From: Lucy Taylor
Sent: 20 December 2024 14:26
To: DC Admin
Subject: FW: 2024/93188 at location Christ Church, Sude Hill, New Mill, Holmfirth, HD9 7ER

From: Conservation Design <ConservationDesign@kirklees.gov.uk>
Sent: 20 December 2024 13:28
To: Lucy Taylor <Lucy.Taylor@kirklees.gov.uk>
Subject: RE: 2024/93188 at location Christ Church, Sude Hill, New Mill, Holmfirth, HD9 7ER

As noted Christ Church, is a Grade II Listed. The Church an active place of worship, therefore, matters relating to the fabric of the building are dealt with under the Church Faculty. The assessment of the proposals is on the visual impact, impact on setting and the way the Church is experienced.

Figure: Overview Image, 3D Design

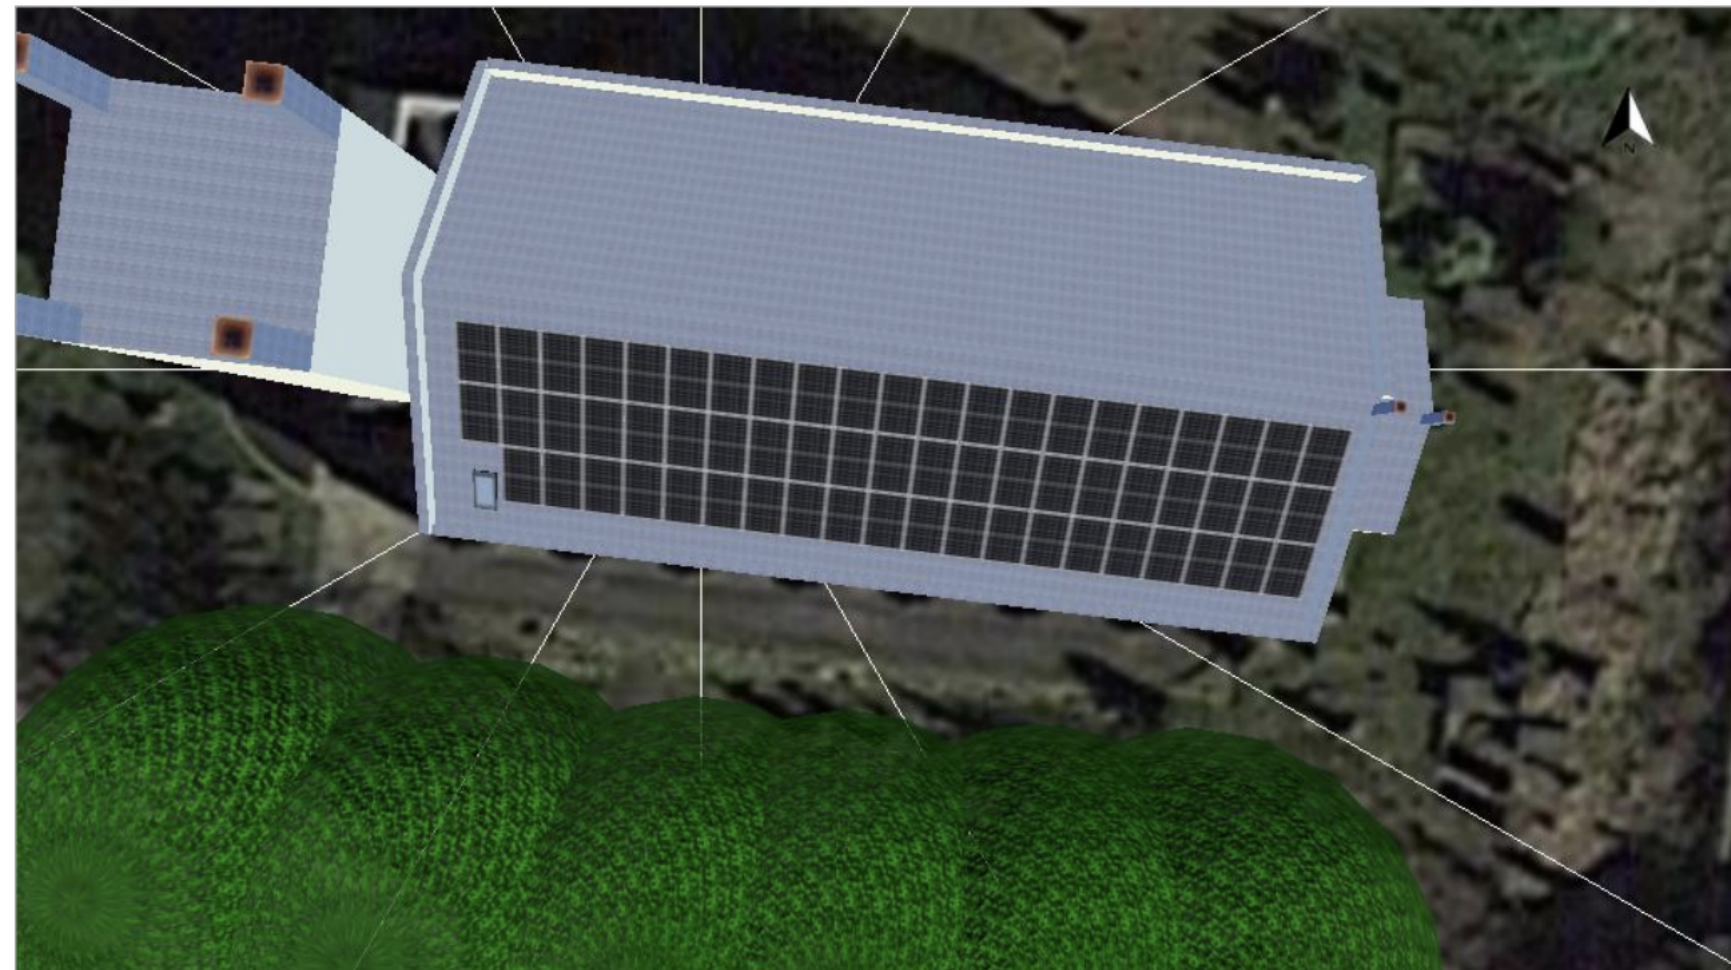
The Church does have a slightly shallower roof pitch and a slight parapet gutter. However, the panels are to be set in the middle of the roof plane. Once fitted the panels will be visible from views off Sude Hill to the south and more so when the trees are not in full leaf. We do however acknowledge that the panels would not be visible from views from the north, nor views when within the Churchyard or looking from the south west. But to reiterate they will be visible when viewed from the south, south east off Sude Hill.

PROJECT	Solar PV Installation
SHEET	Proposed Layout

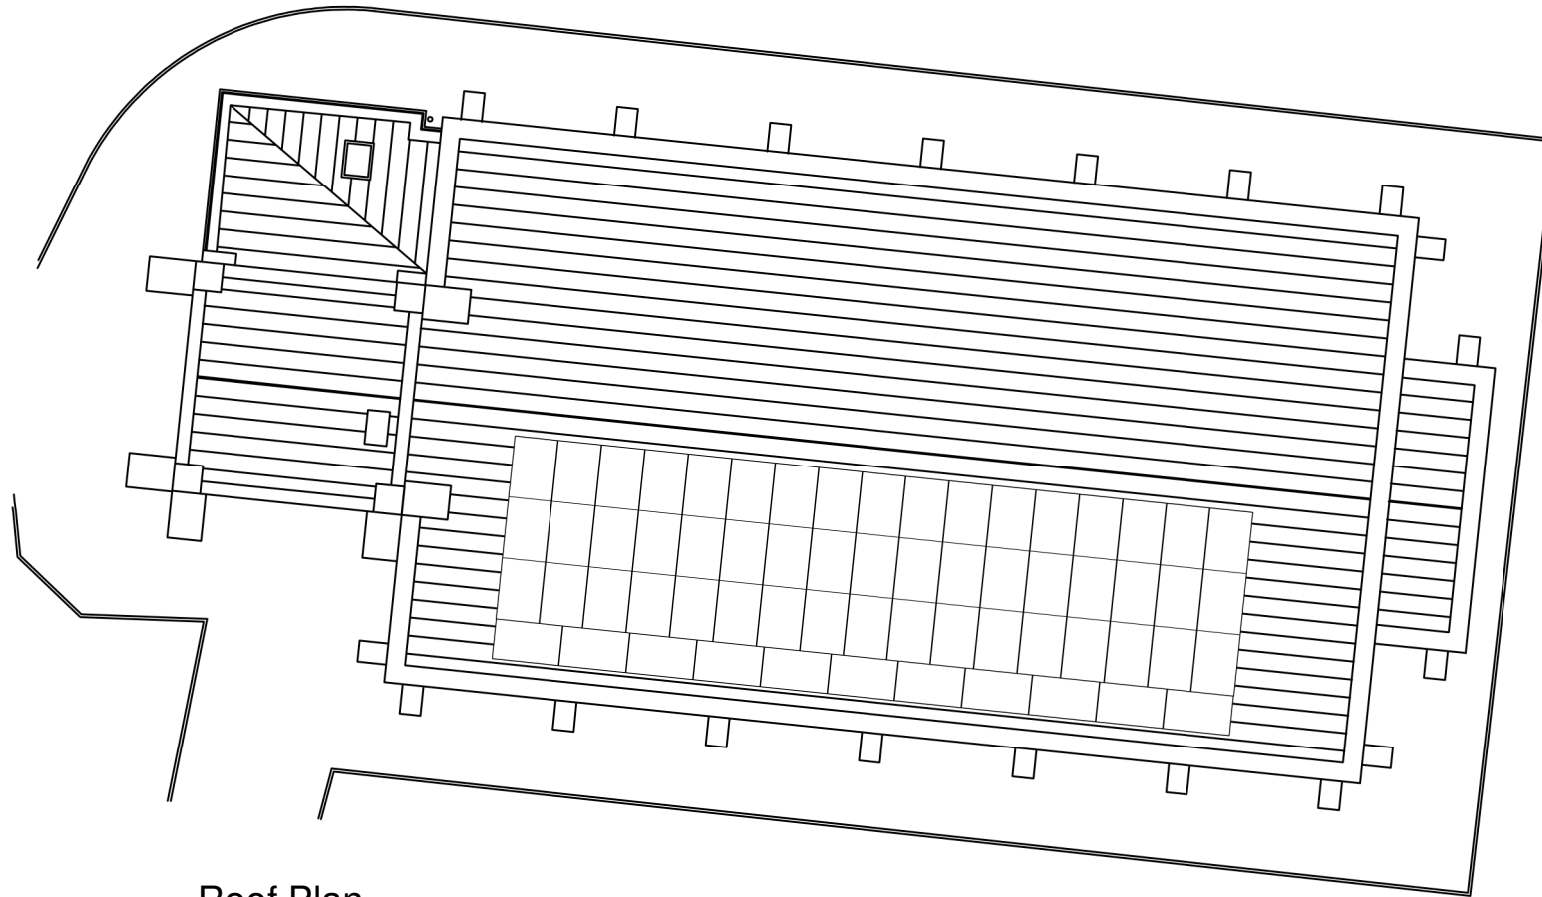
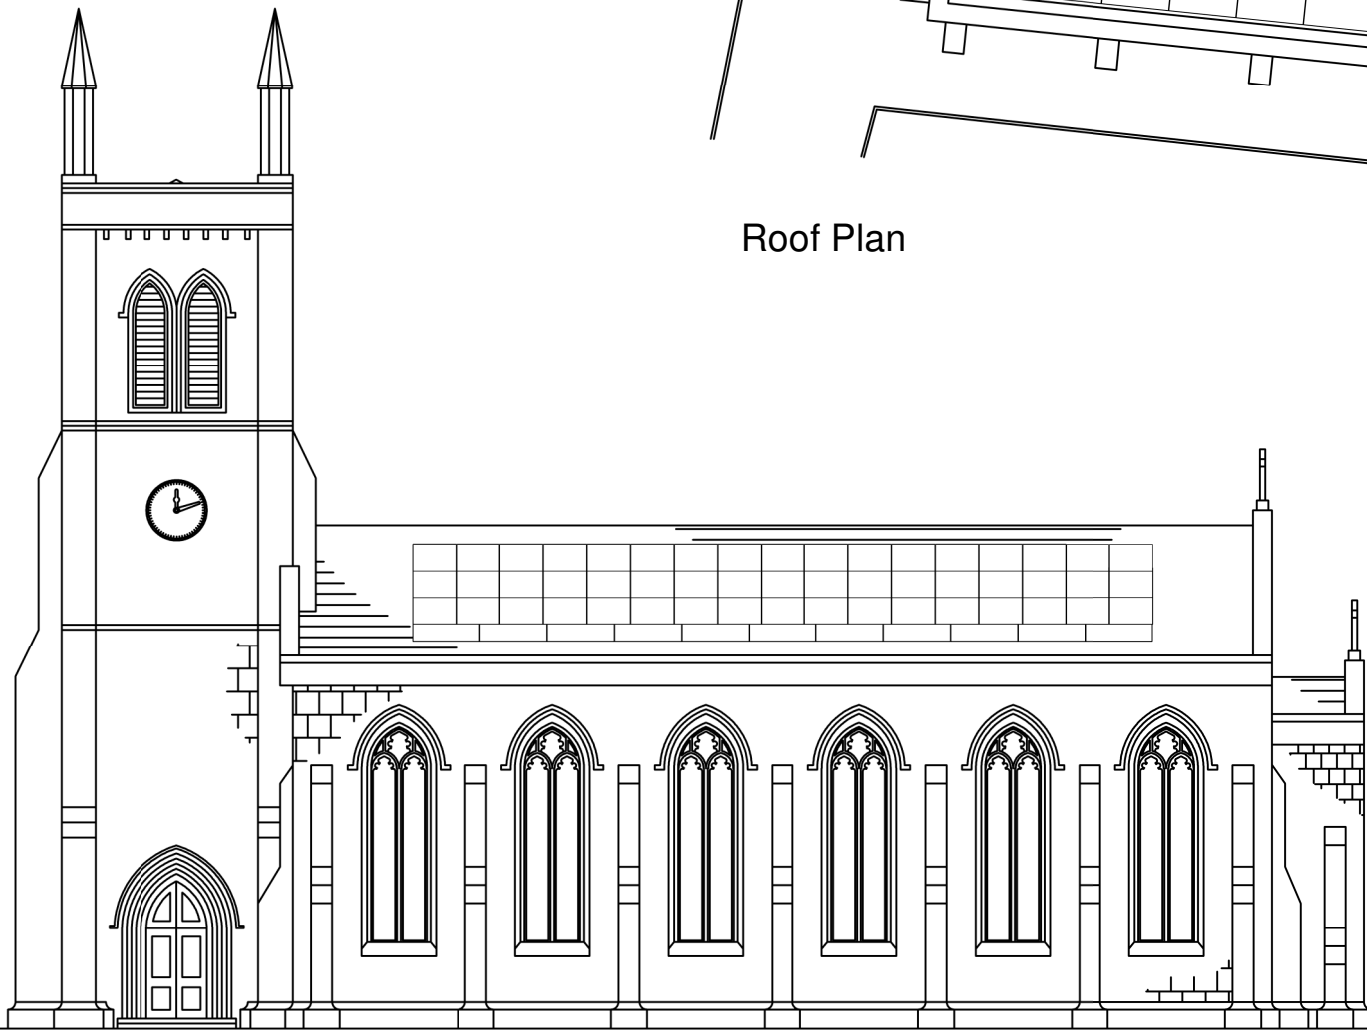
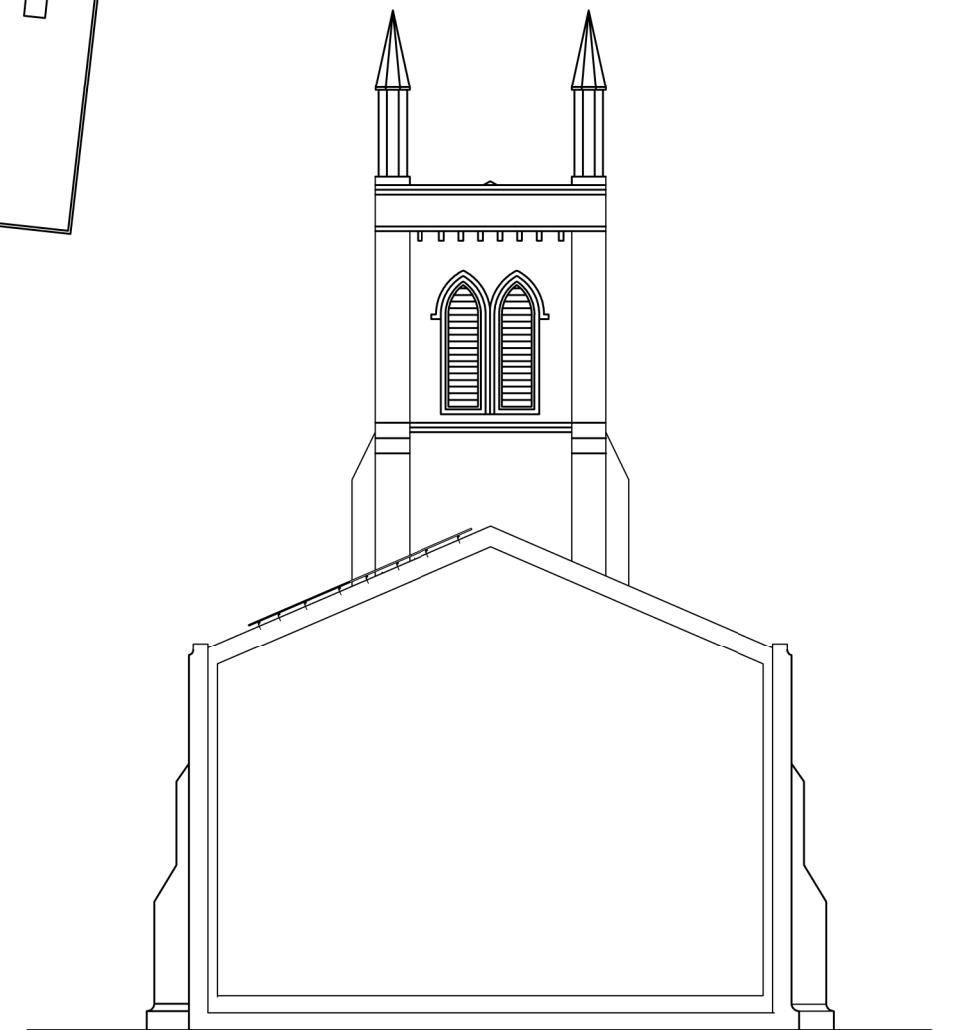
Conservation has concerns with the proposals and the way this will impact the way the Church is appreciated. The panels will be partially screen during the months of full leaf but will be visible during the autumn and winter months and the panels will have a negative impact. We appreciate the reasons set out for the fitting of solar panels, however, we are not convinced this is the only approach which could be considered. There are other options which could be considered which would have a lesser degree of impact and achieve the same aims. We would also note that while solar panels provide sustainable energy, they themselves are not sustainable, as panels have a limited life span (with lab testing suggestive of 25 years, but real-world factors have not been taken into account) and currently there is limited ability to recycle spent panels.

On balance we consider the proposed would cause less than substantial harm which as set out under the NPPF would be required to be balanced against the public benefits, and where applicable against secure the long term viable use of the building. We consider that a row, possible 2 rows of panels closest to the parapet may be possible, with a lesser impact. We would also suggested look to fit panels to the roof of the tower,

which will have minimal impact. We would also advise looking at alternative options such as ground/ air source heating.
